**PLANNING & ECONOMIC DEVELOPMENT  
WICKLOW COUNTY COUNCIL**

Shankill Propertys Investments Ltd has applied on 27/09/2022 for STRATEGIC HOUSING DEVELOPMENT for Change of use of lands former course use to residential and other uses consisting of 586 no. residential units and c.1,583 sqm of other uses comprising of 1 no. retail unit, a childcare facility, a café and 1 no. commercial unit (incorporating a gym and juice bar) of theses, 234 no. residential units, c. 1071sqm of the other uses and associated site landscaping and site development works were previously permitted by An Bord Pleanala under ABP Ref. 311181-21, and they from part of this current application again. The proposed development will also include all associated plant; refuse storage areas; communal open space; public open space; playgrounds; multi use games area, associated internal roads and drainage arrangements; utility connections; pedestrian/cycle linkages with adjoining sites; landscaping' public lighting; construction compounds; and all site development works at former Bray Golf Club off Ravenswell Road and the Dublin Road Bray

From:	Declan O'Brien Executive Engineer TWES	To:	Michael Flynn Senior Engineer TWE

Title		PROPOSED PUBLIC LIGHTING LAYOUT - SHEET 1 OF 2			
Original Scale	1:500 at A1 1:1000 at A3	Design/Drawn	RRT	Checked	AK
Date	02.09.22	Date	02.09.22	Date	02.09.22
Status	P	Drawing Number	5214419-ATK-01-ZZ-DR-EE-1301	Rev	P01

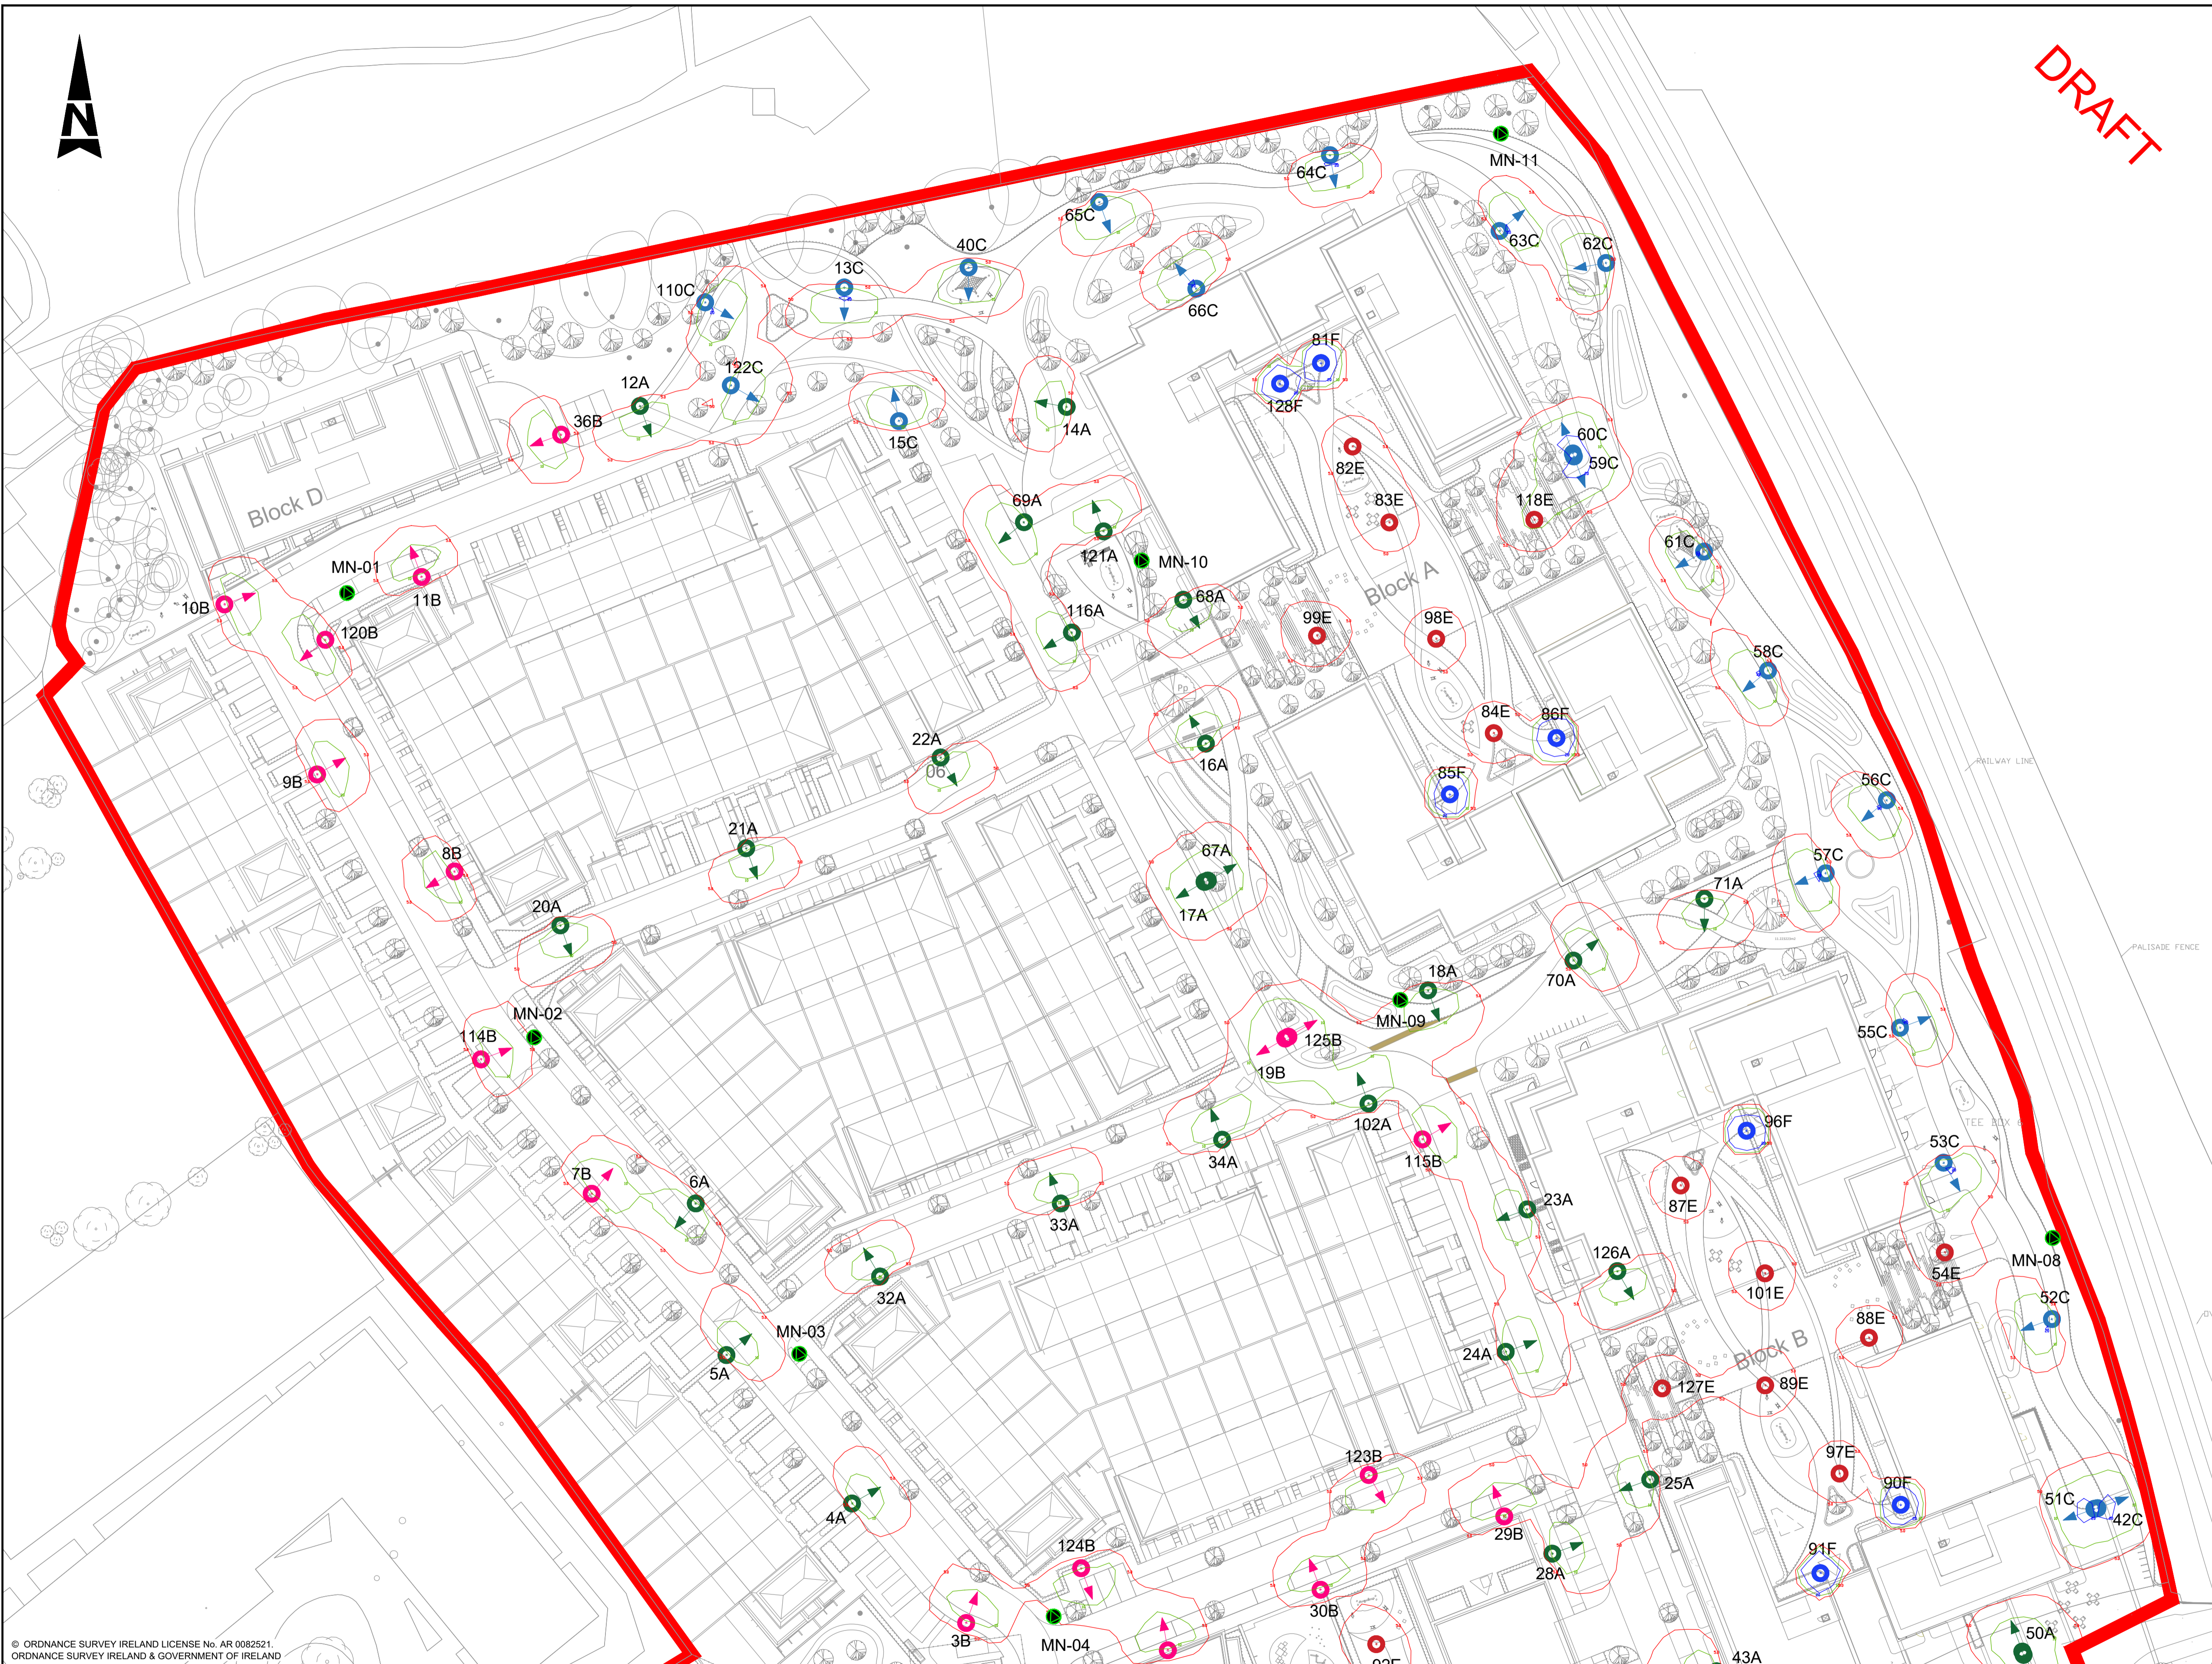
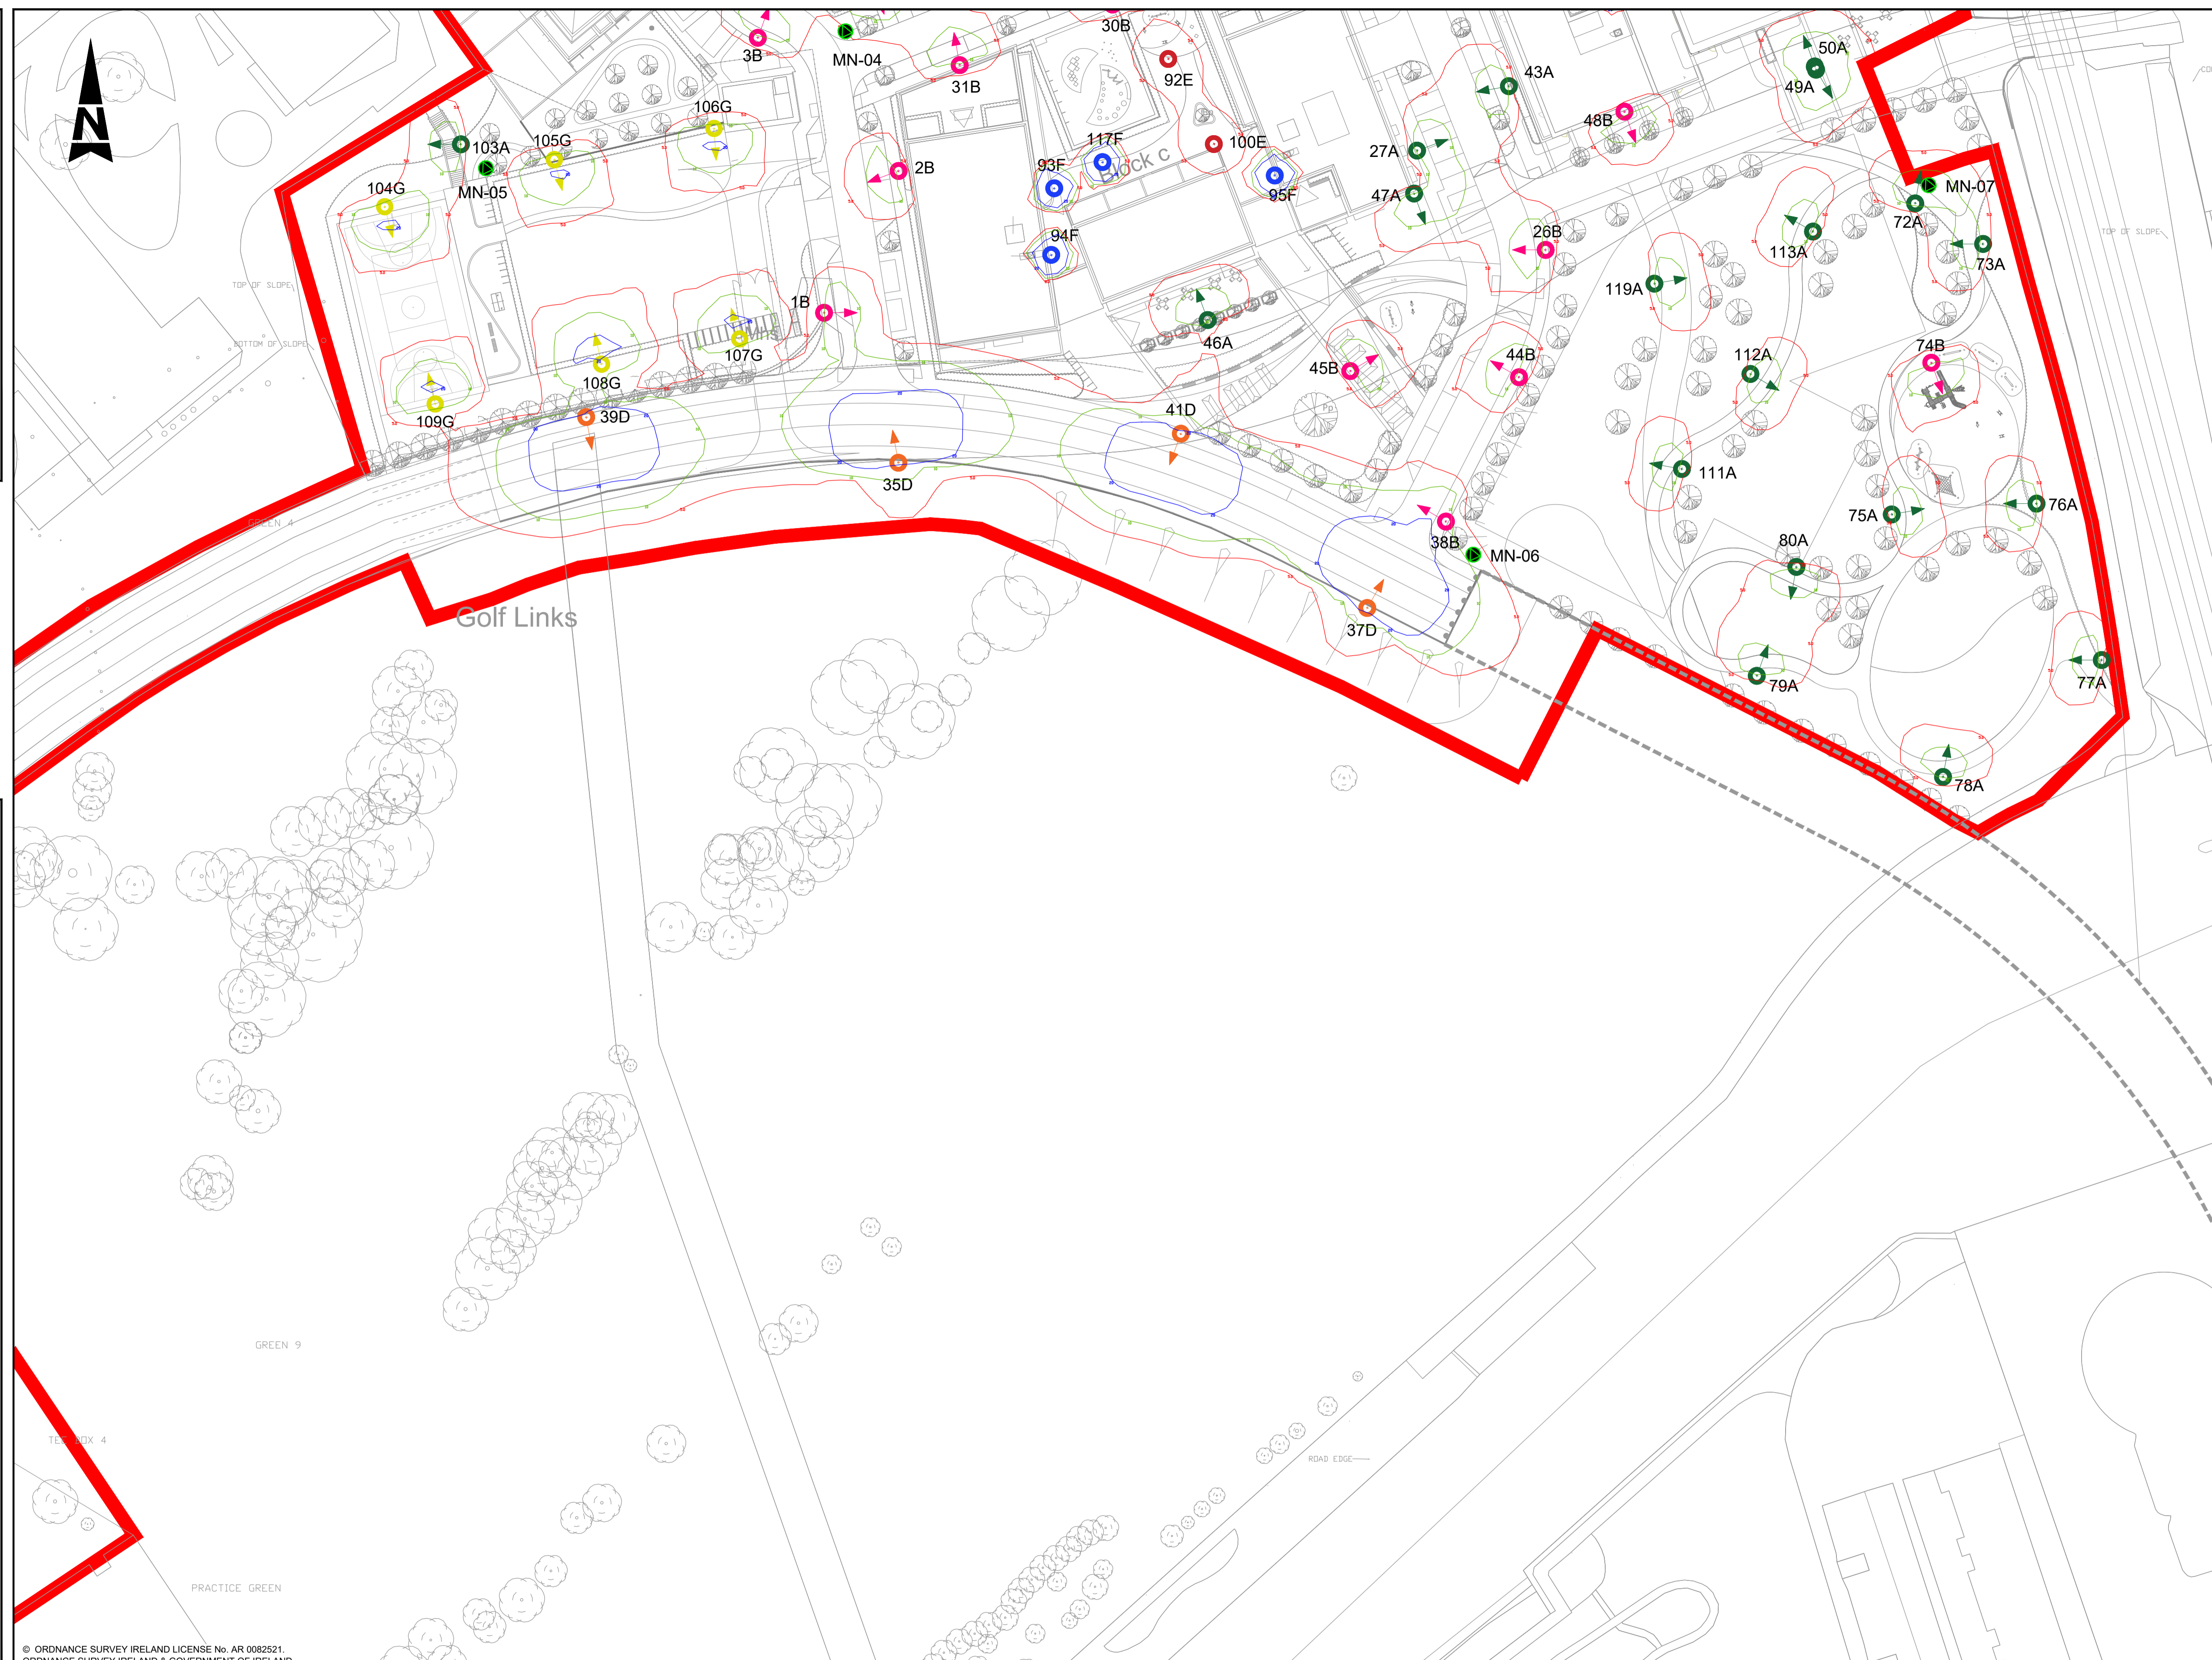
- PL1. Public Lighting design is noted, however in the event that the application is granted permission the application should be conditioned to agree any design with the respective Authorities prior to commencement of development and should in particular address the following:
- A map showing the public lights to be taken in charge by the Council.
  - Any lights to be taken in charge by the Council must be connected to an independent power supply.
  - Any public lighting that is to be taken in charge located in either Local Authority Area shall be feed from an independent supply so that each Local Authority can control and maintain those lights within their functional area.

**Refer to Condition 14**
